# CLAREMONT BUSINESS PARK 2 FILING NO. 2

A REPLAT OF LOTS 8, 9, & 10, AND TRACT B "CLAREMONT BUSINESS PARK 2 FILING NO. 1", BEING A TRACT OF LAND IN THE SOUTHEAST QUARTER OF THE SOUTHEAST QUARTER (SE 1/4, SE 1/4) OF SECTION 5 AND NORTHEAST QUARTER OF THE NORTHEAST QUARTER (NE 1/4, NE 1/4) OF SECTION 8, T14S, R65W, OF THE 6TH P.M., EL PASO COUNTY, COLORADO

# V1\_Final Plat Redlines.pdf Markup Summary

FINAL PLAT
CLAREMONT BUSINESS PARK 2 FILING NO. 2
JOB NO. 10-020
DATE PREPARED: 02/27/2023
DATE REVISED: 04/10/2023

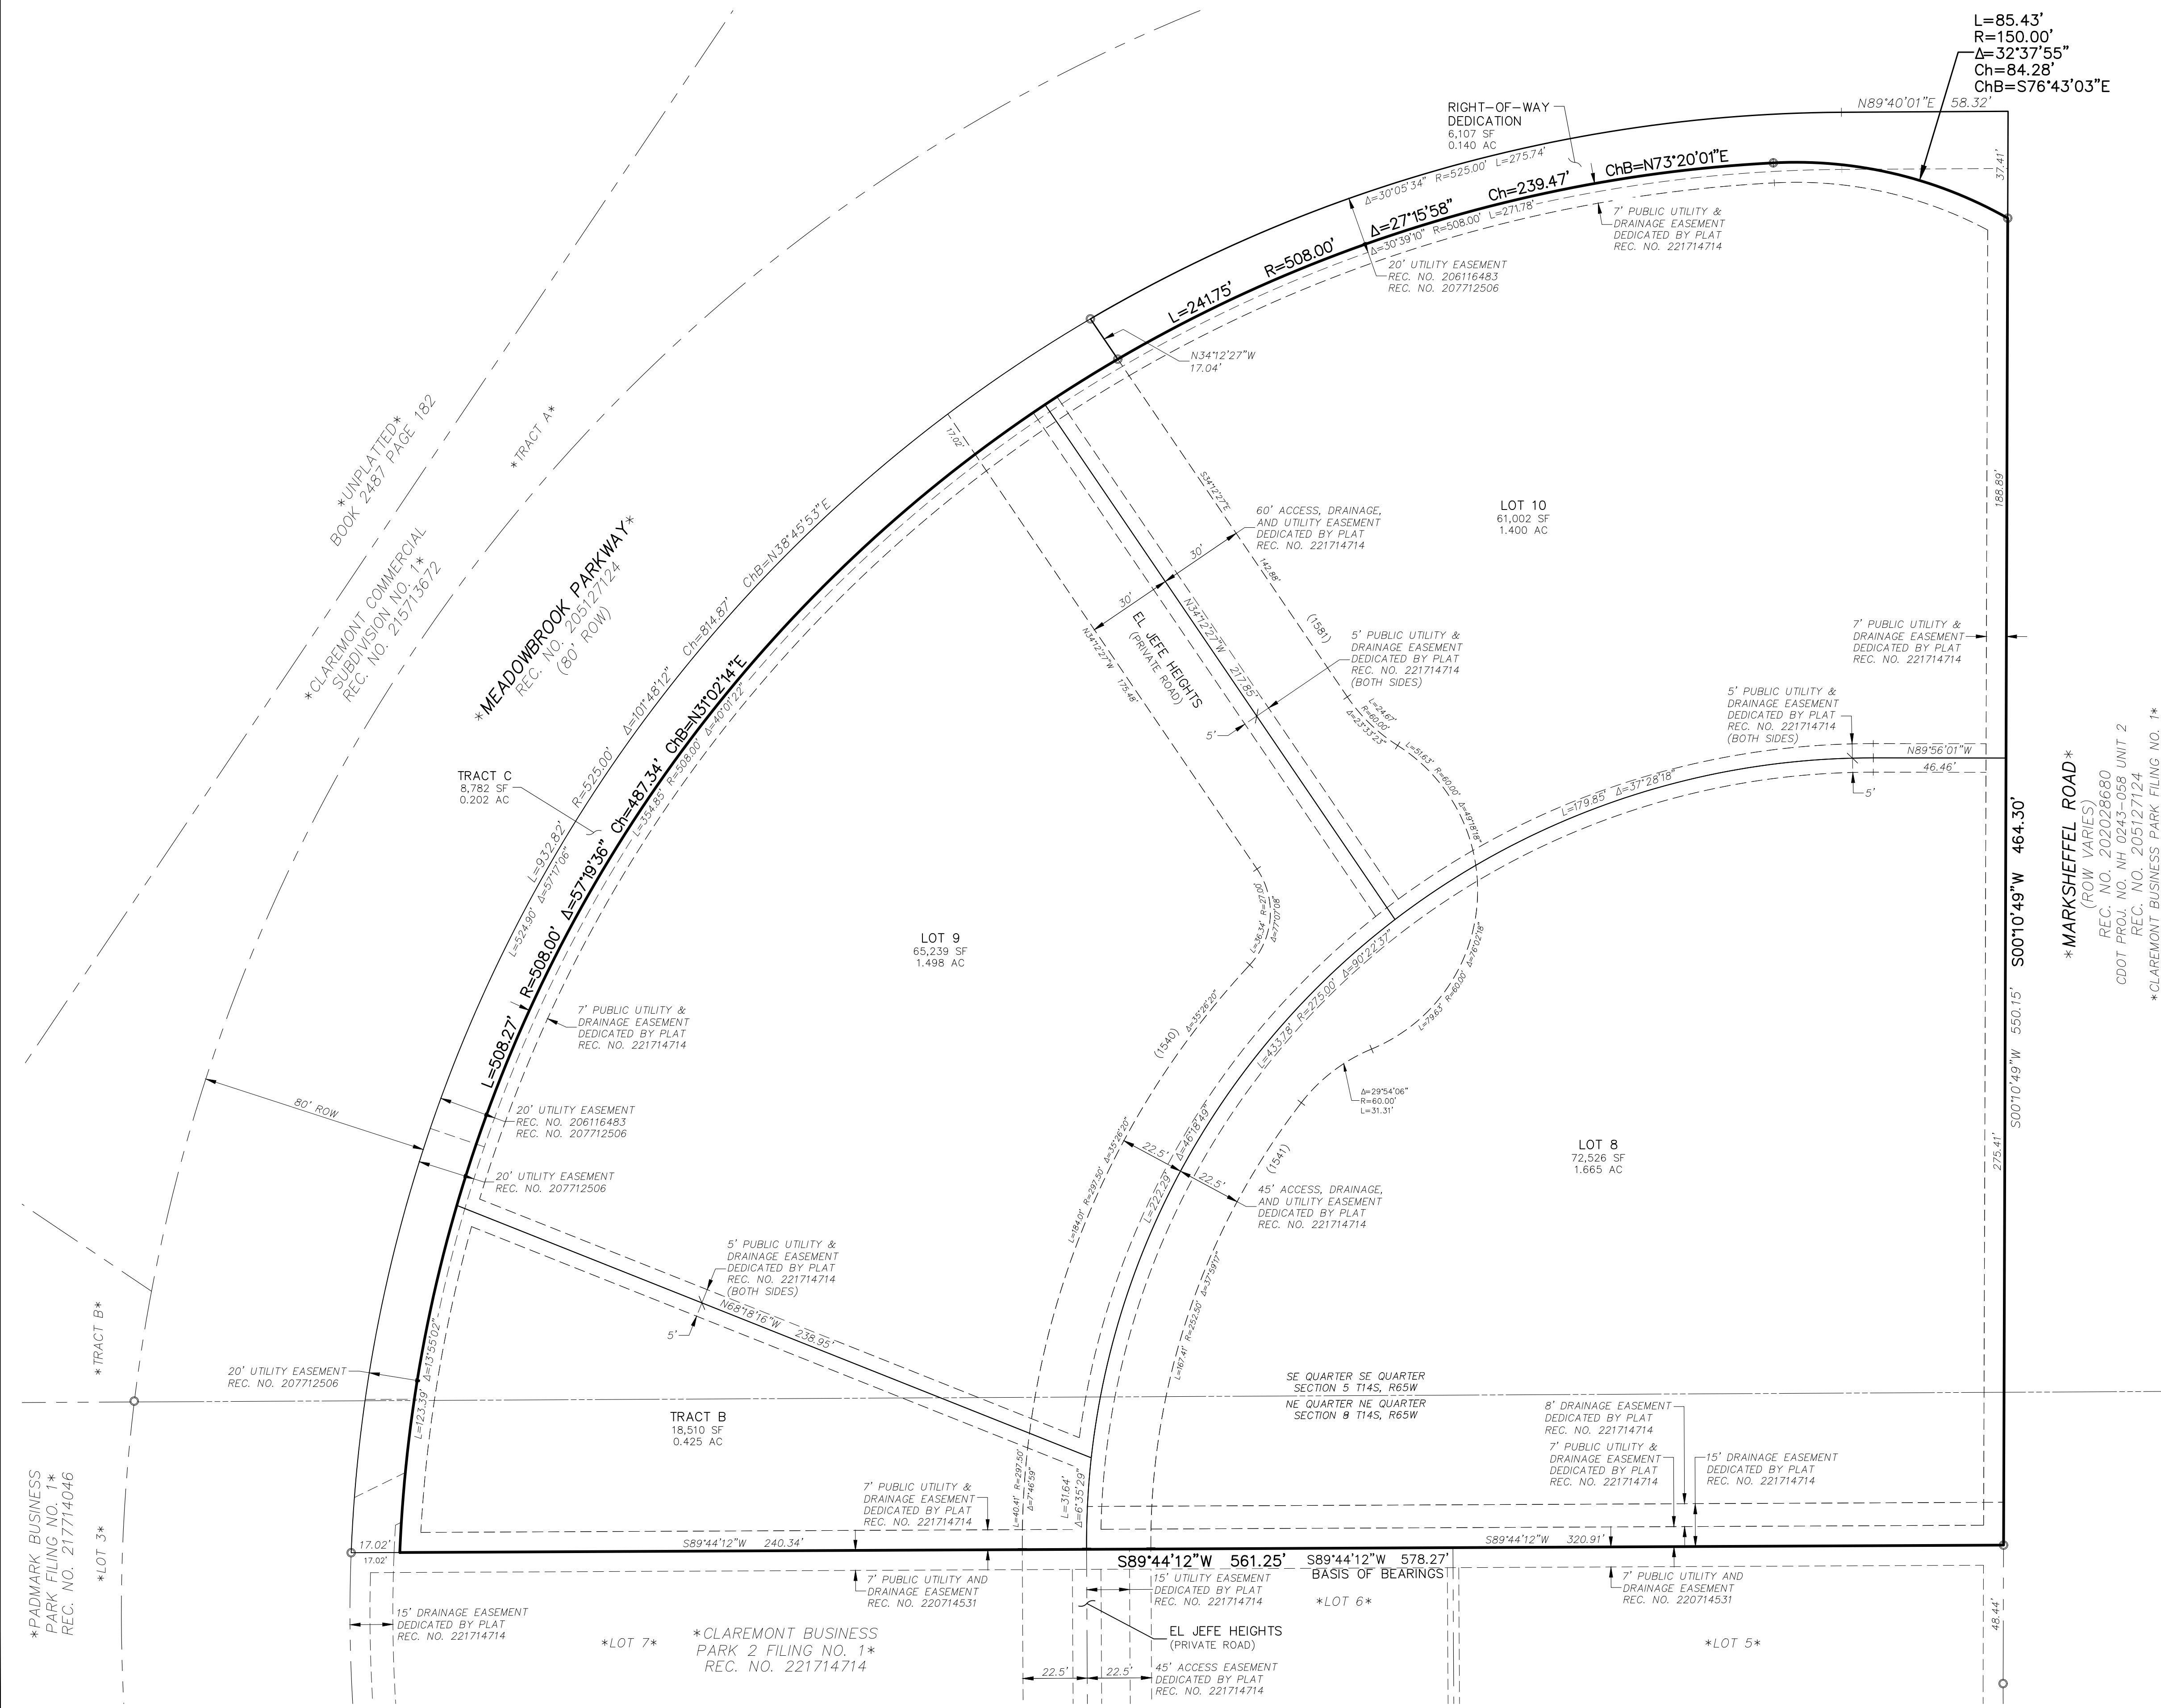
Should be number 12, fix all numbers after

AS REPLATTED

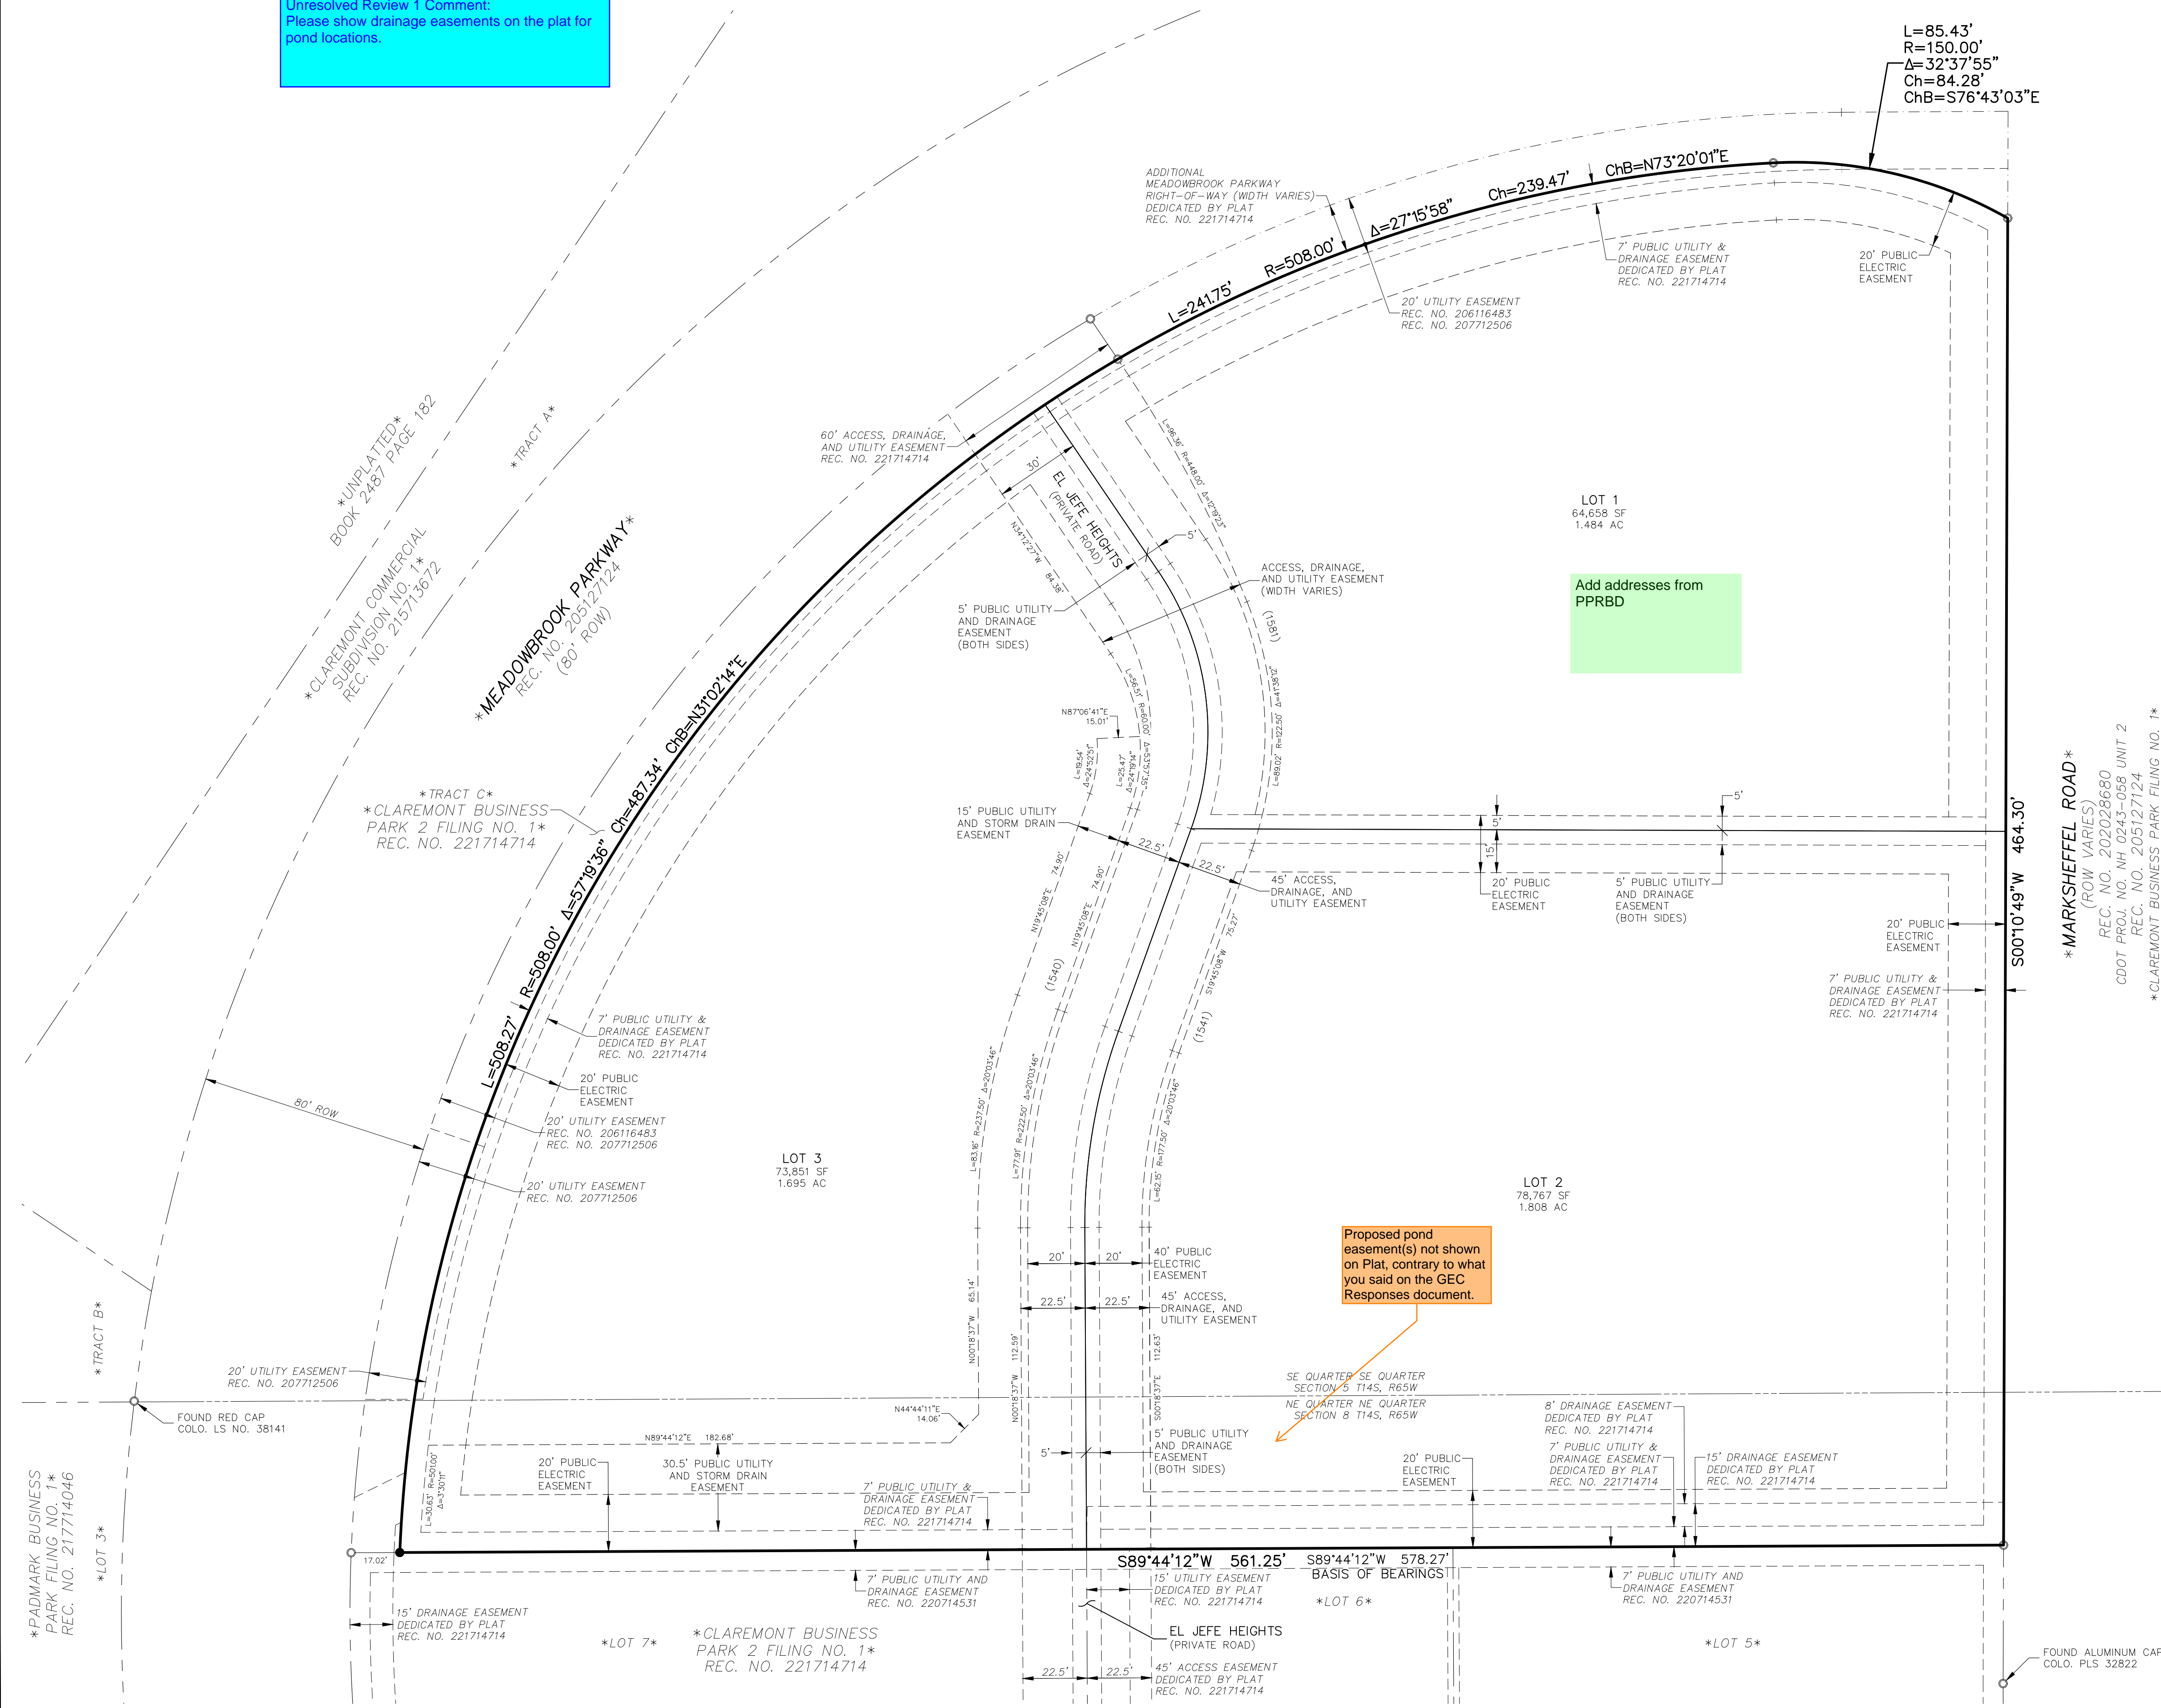
Show drainage easements for the locations of the ponds
